**Consultation Response from KC,
Lead Local Flood Authority**

2022/90752 Land at Hart Street, Newsome, Huddersfield, HD4 6LS

Discharge of condition 3 (surface water drainage in highway) of previous Reserved Matters consent 2021/91638 pursuant to outline permission 2016/91479 (appeal APP/Z4718/W/17/3173711) for erection of 22 dwellings

Date Responded: 1st April 2022

Title
Proposed External Works

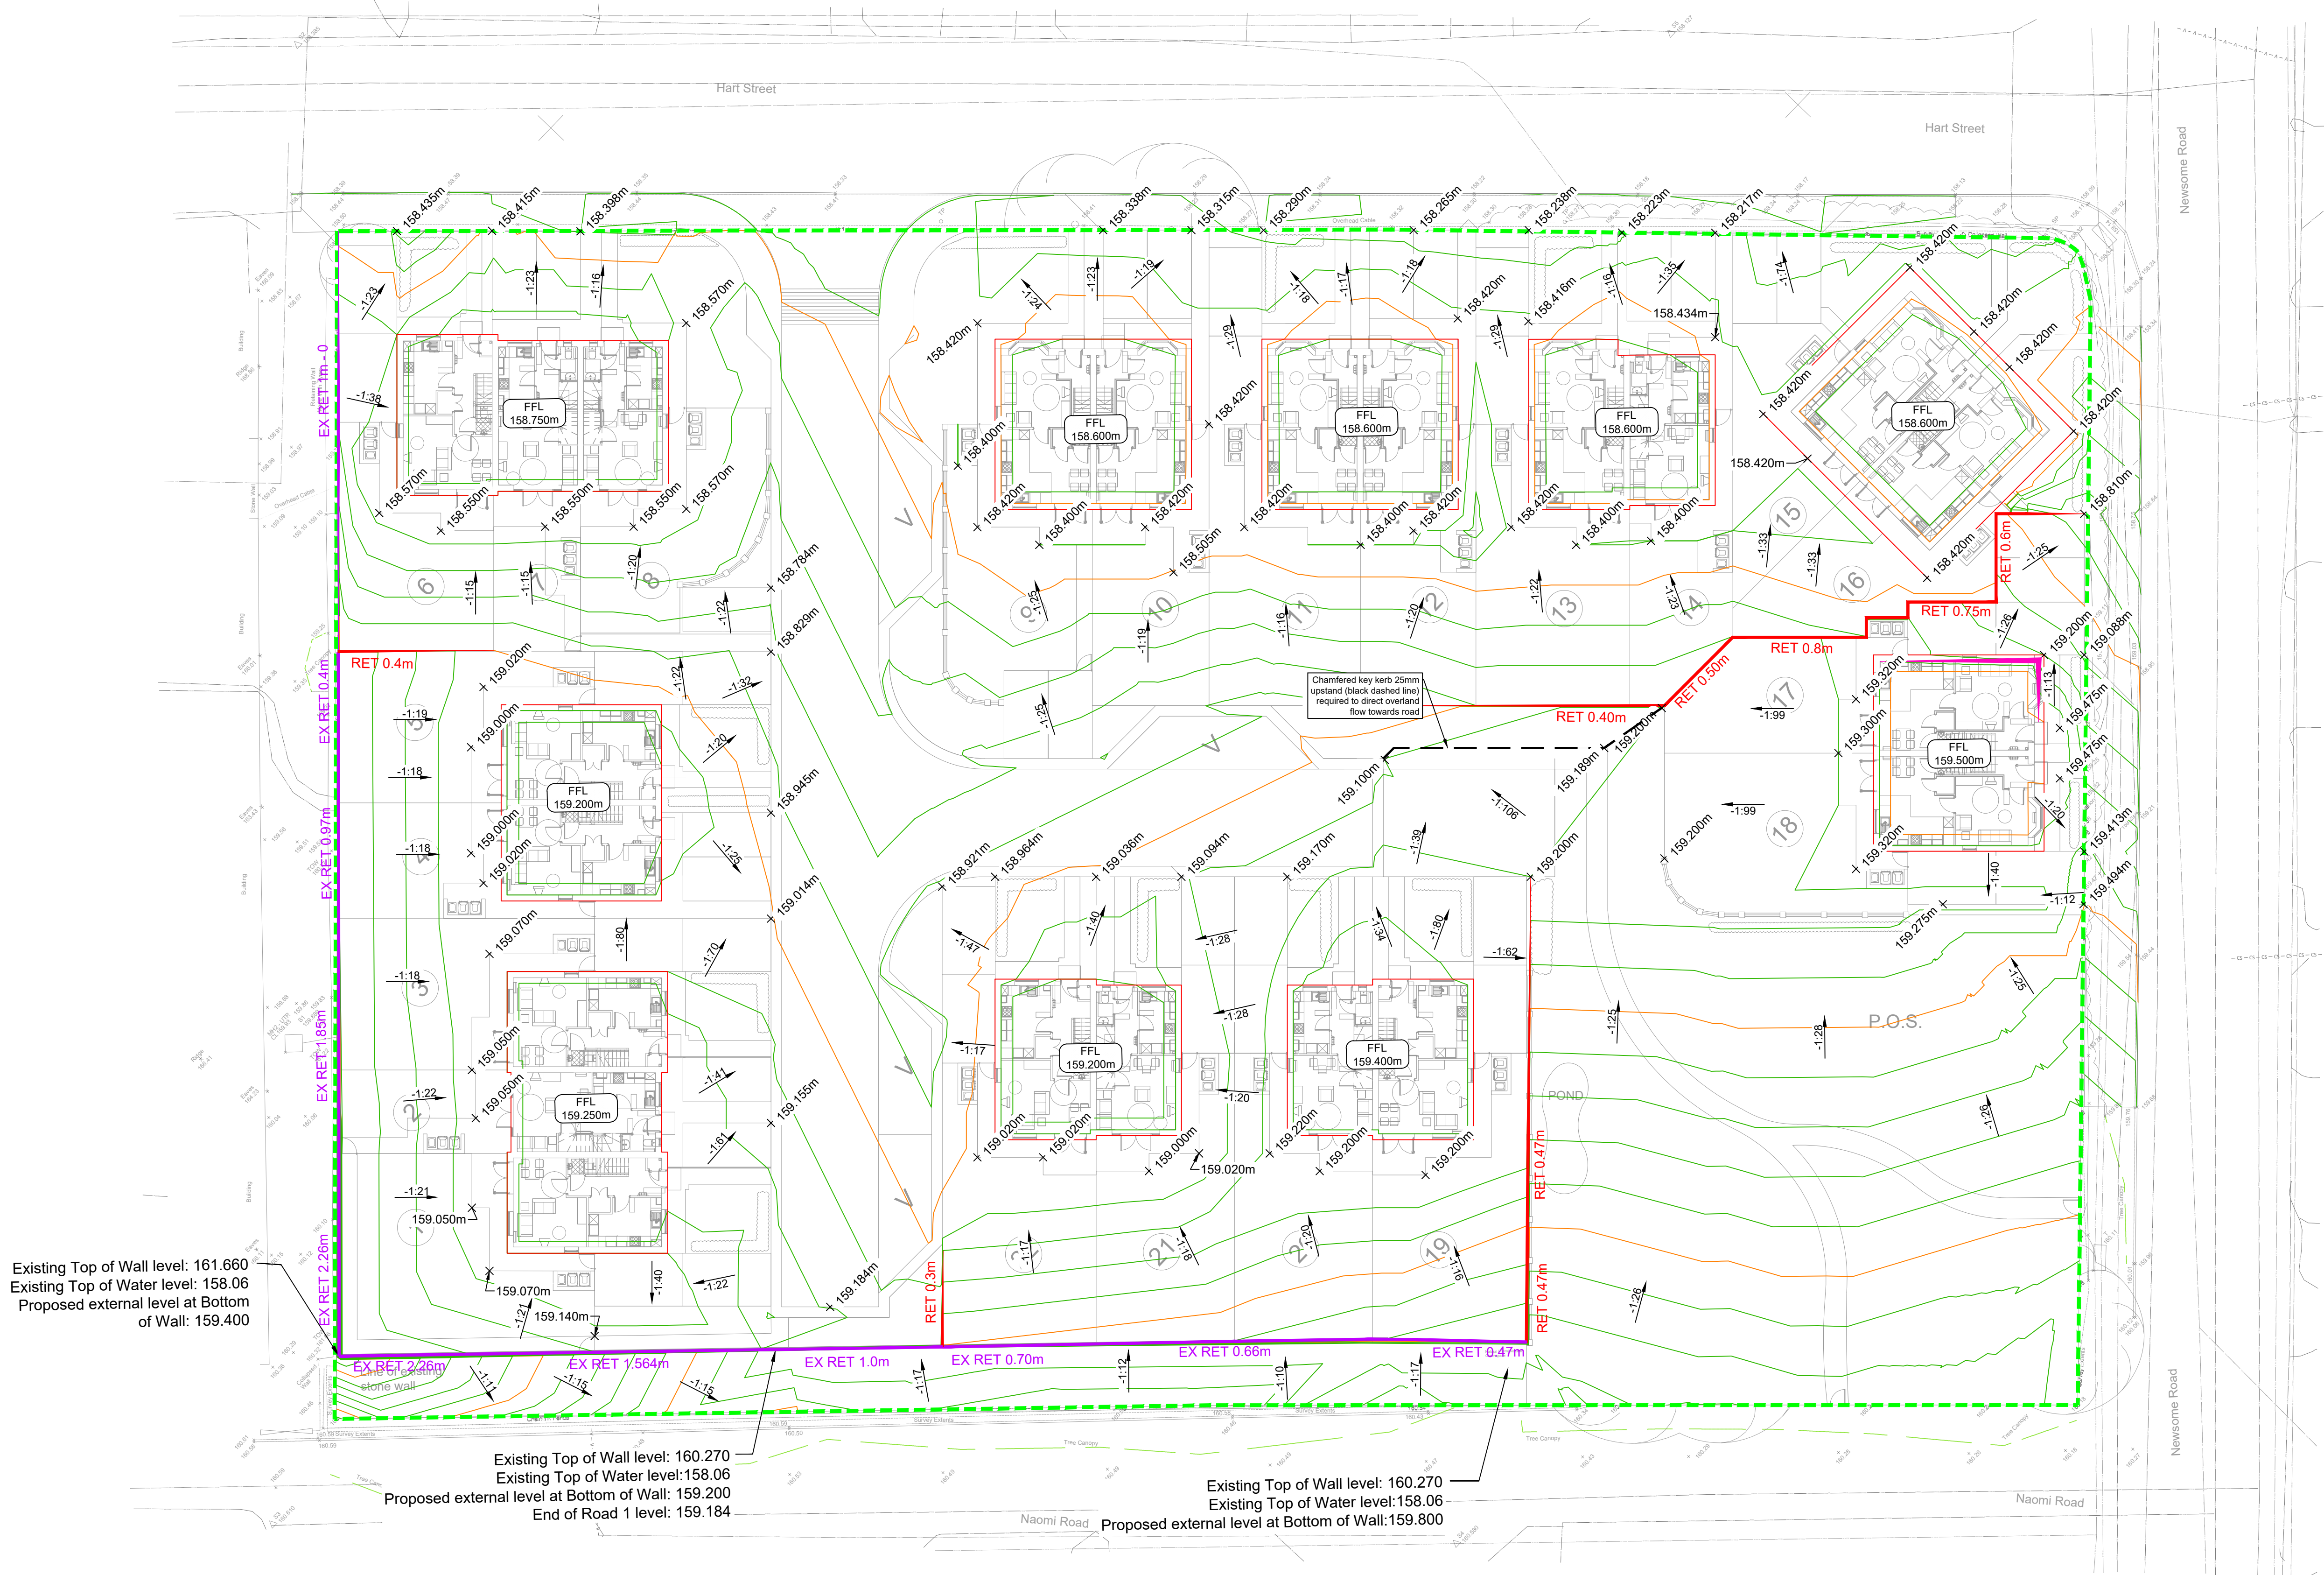
Kirklees Flood Management continues to OBJECT to this application as submitted drawings show a flood route from attenuation exceedance entering property curtilage. It is strongly advised and rejected previously, that housing estates should not use cellular storage for attenuation as this does not allow the adequate inspection and maintenance and management required in comparison to other designs, for the LLFA to fulfil its obligations to ensure adequate maintenance and management for the life of the site.
